Appeal Decisions

Appeal A Ref: APP/R5510/W/24/3340797

50 Tudor Lodge Hotel, Field End Road, Hillingdon, Ruislip HA5 2QN

Appeal B Ref: APP/R5510/Y/24/3340798

Rev	Date	Note
P1	13-07-23	PLANNING ISSUE
P2	08-09-23	PLANNING ISSUE
PROJECT		
Tudor lodge Hotel, 50 Field End Road HA5 2QN		
DRAWING TITLE		
PROPOSED GF PLAN 2 OF 2		
STATUS		
PLANNING APPLICATION		
DRAWN BY		CHECKED BY
Author		Checker

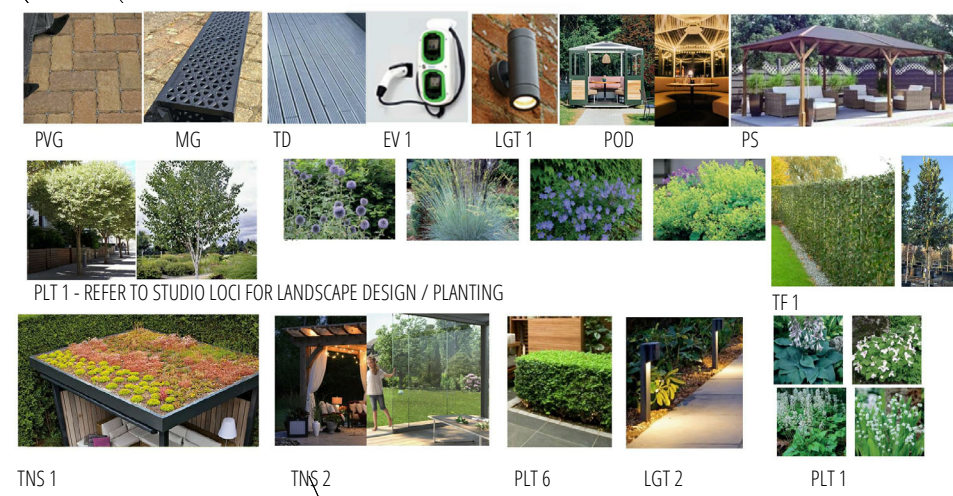
20. The proposal would involve the resurfacing and expansion of hardstanding materials for the alteration to the car parking layout and the proposed outdoor dining areas, the majority of which would also be located to the south-west of the site. This would include tarmac surfaces, painted lines, additional cars, and outdoor seating. Consequently, the ability of the viewer to appreciate the special historic interest and significance of the listed building from these locations would be adversely affected to a high degree. The proposed fencing and landscaping would partially screen some of the views of the pergola and hardstanding areas, but views would still be visible from the road and from within the site itself.

41. The landscape design plan identifies 4 of the trees (T18, T19, T20 and T32) for removal. However, these trees have significant amenity value due to their size and arrangement. In combination, the removal of these trees and their substitution with built form would have a significant and detrimental effect upon the landscape character of the area.

Rev	Date	Note
P1	13-07-23	PLANNING ISSUE
P2	08-09-23	PLANNING ISSUE
PROJECT		
Tudor lodge Hotel, 50 Field End Road HA5 2QN		
DRAWING TITLE PROPOSED FRONT ELEVATION		
STATUS PLANNING APPLICATION		
DRAWN BY Author		CHECKED BY Checker

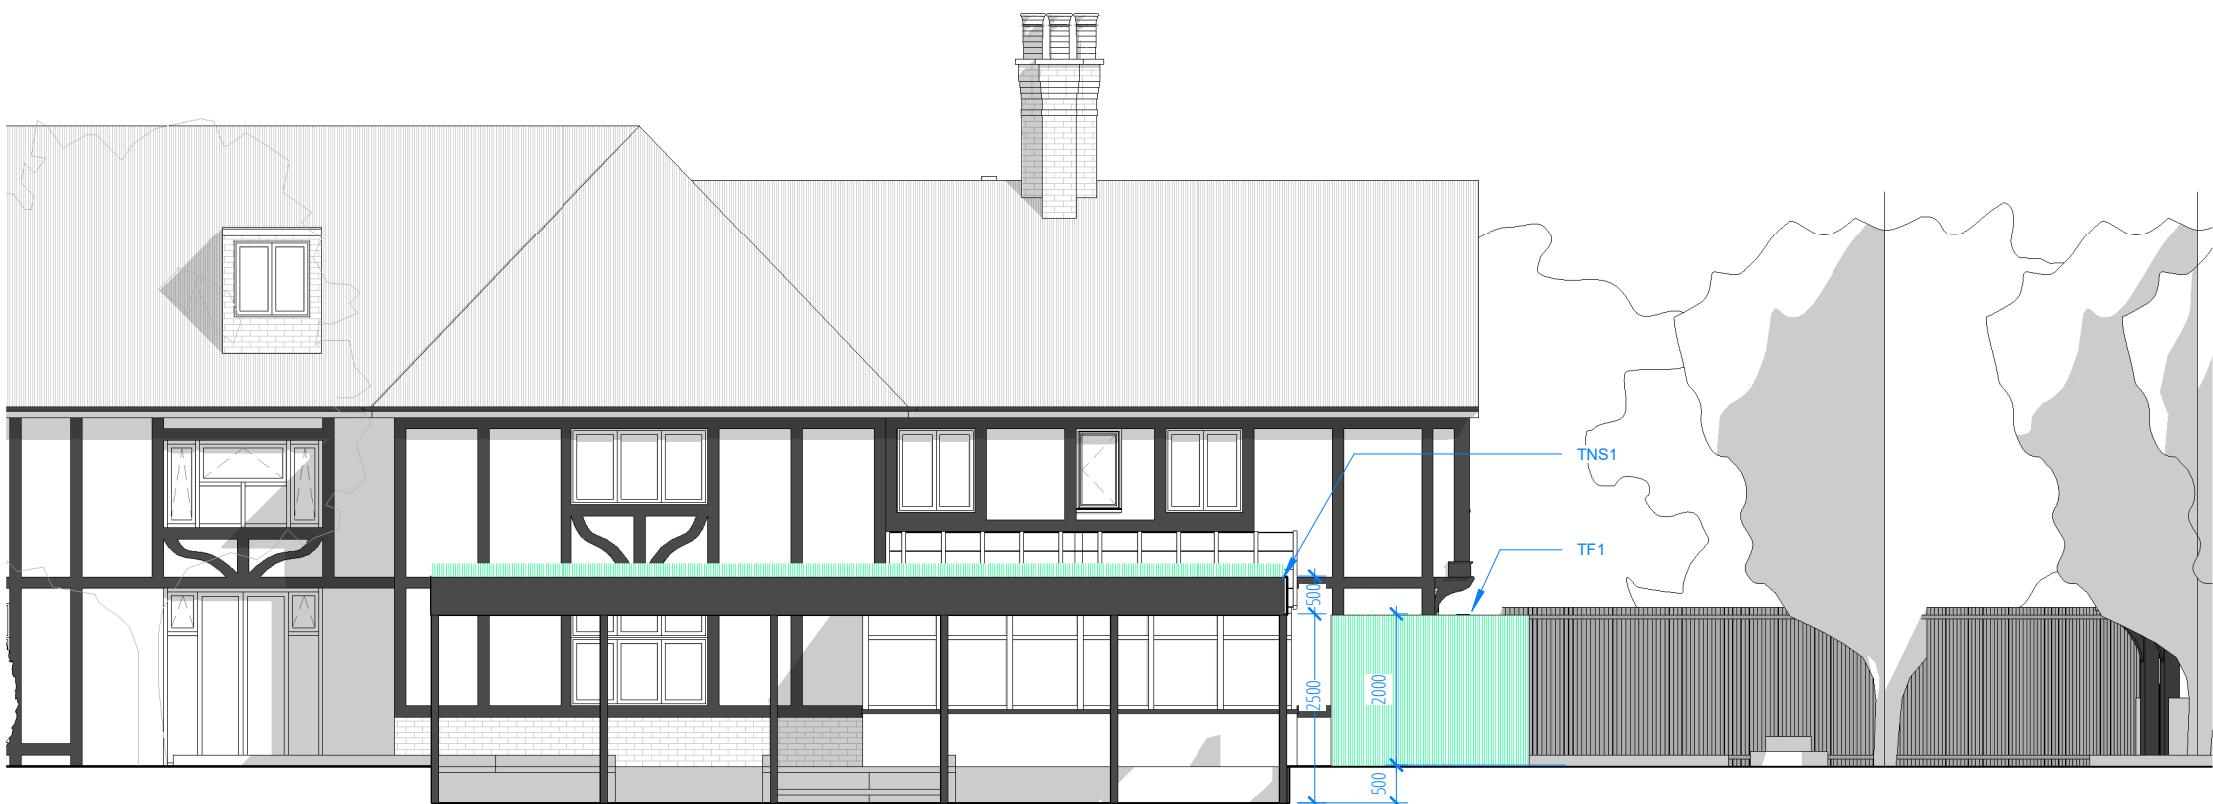
18. The proposal would include a sunken paving area with a large pergola. The pergola would be constructed from timber with evenly spaced uprights and neatly formed corners with a solid living meadow roof. The pergola's box frame design with a solid flat roof would suggest a modern addition, inconsistent with the sloping and tiled roof form, white render finish, and decorative timber elements of the listed building. It would visually clash with the historic character and traditional design of the listed building, detracting from its appearance. Moreover, its substantial width and height combined with its solid roof form would create a shaded area beneath. Thus, the structure would obscure and interfere with the historic features on the listed building's front elevation, diminishing the way the building's architectural detailing is experienced.

19. Consequently, the proposal would introduce a discordant and prominent feature that would draw attention away from the historic features of the building's front elevation to the detriment of the designated heritage asset. This would undermine the authenticity and integrity of the heritage asset.

DRAWING TITLE
PROPOSED FRONT ELEVATION 2

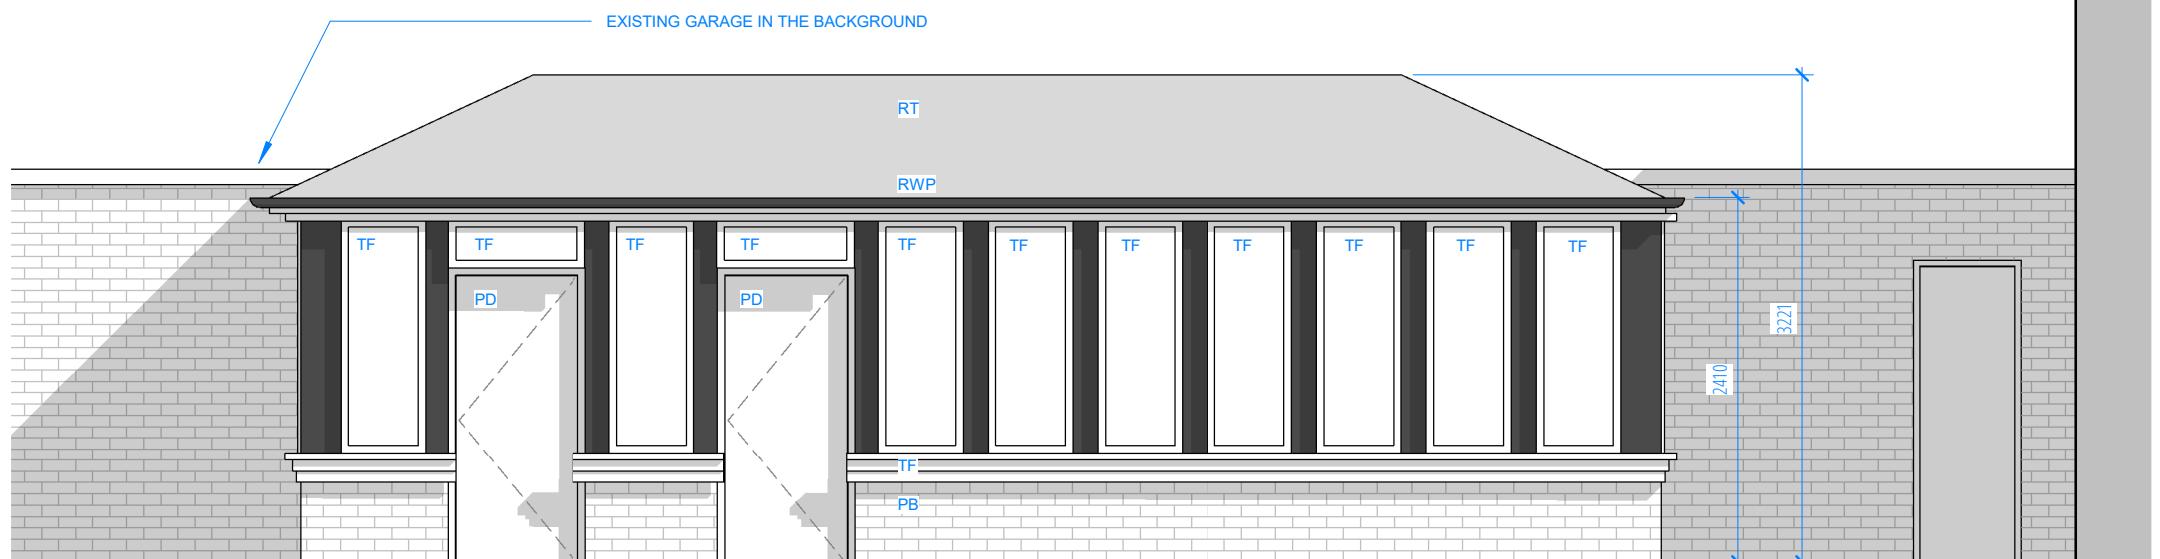
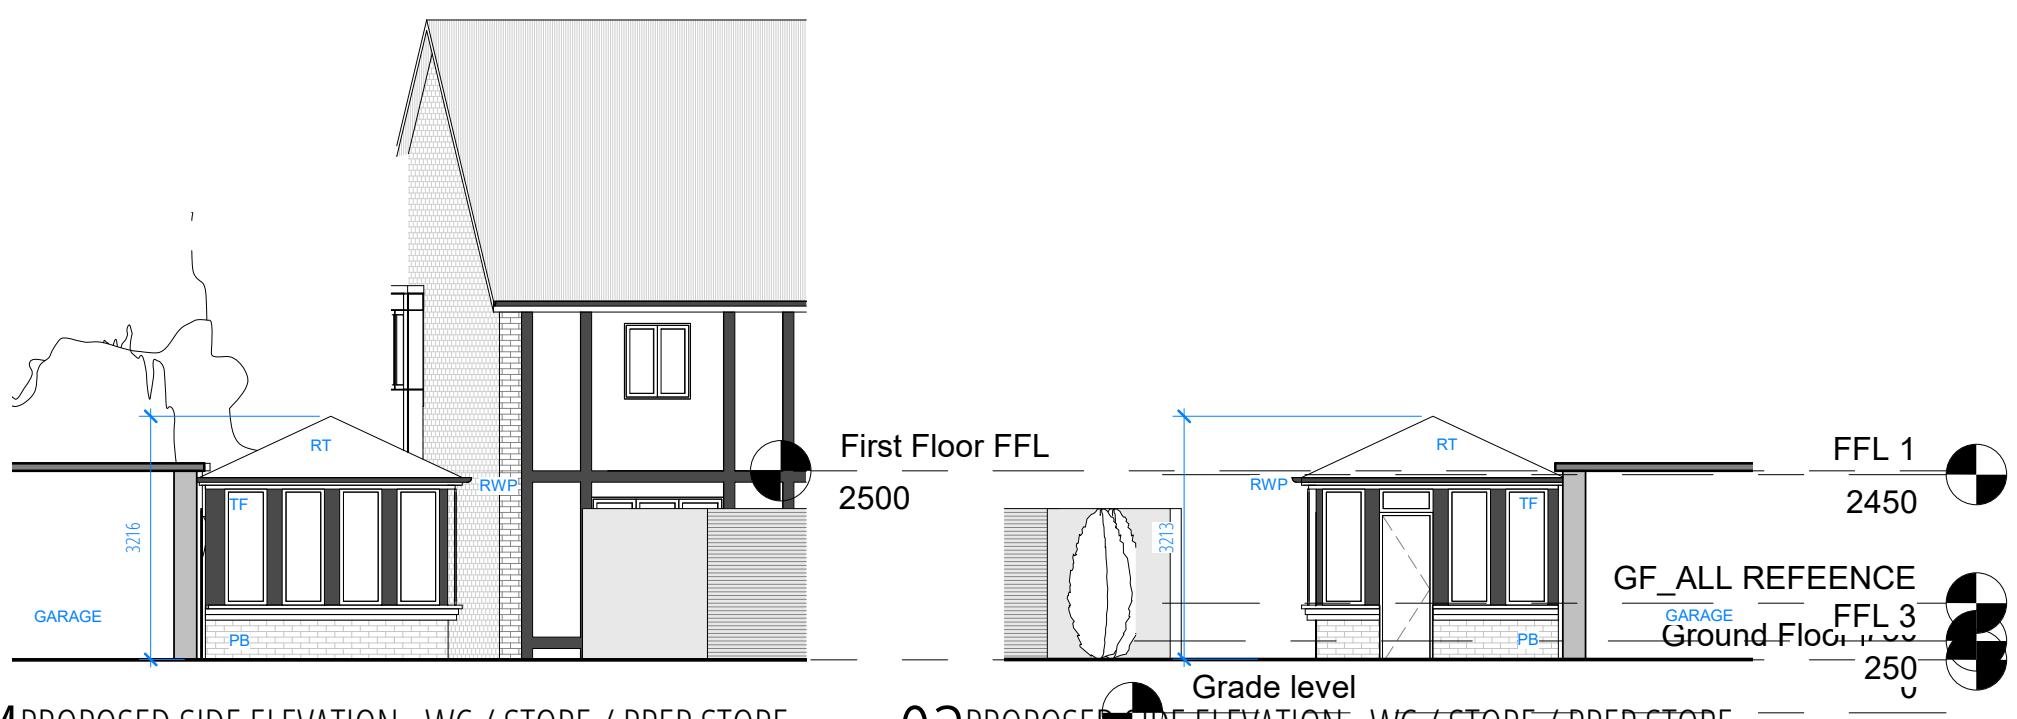
22. The proposal would also include the replacements of two sheds with a detached outbuilding for WC and storage. The proposed siting, design and size of this outbuilding would hold a subservient relationship to the listed building by reason of its simpler form and detailing. In contrast, the proposed pergola's conspicuous design and overtly modern features would dilute the listed building's historic character to the detriment of its significance.
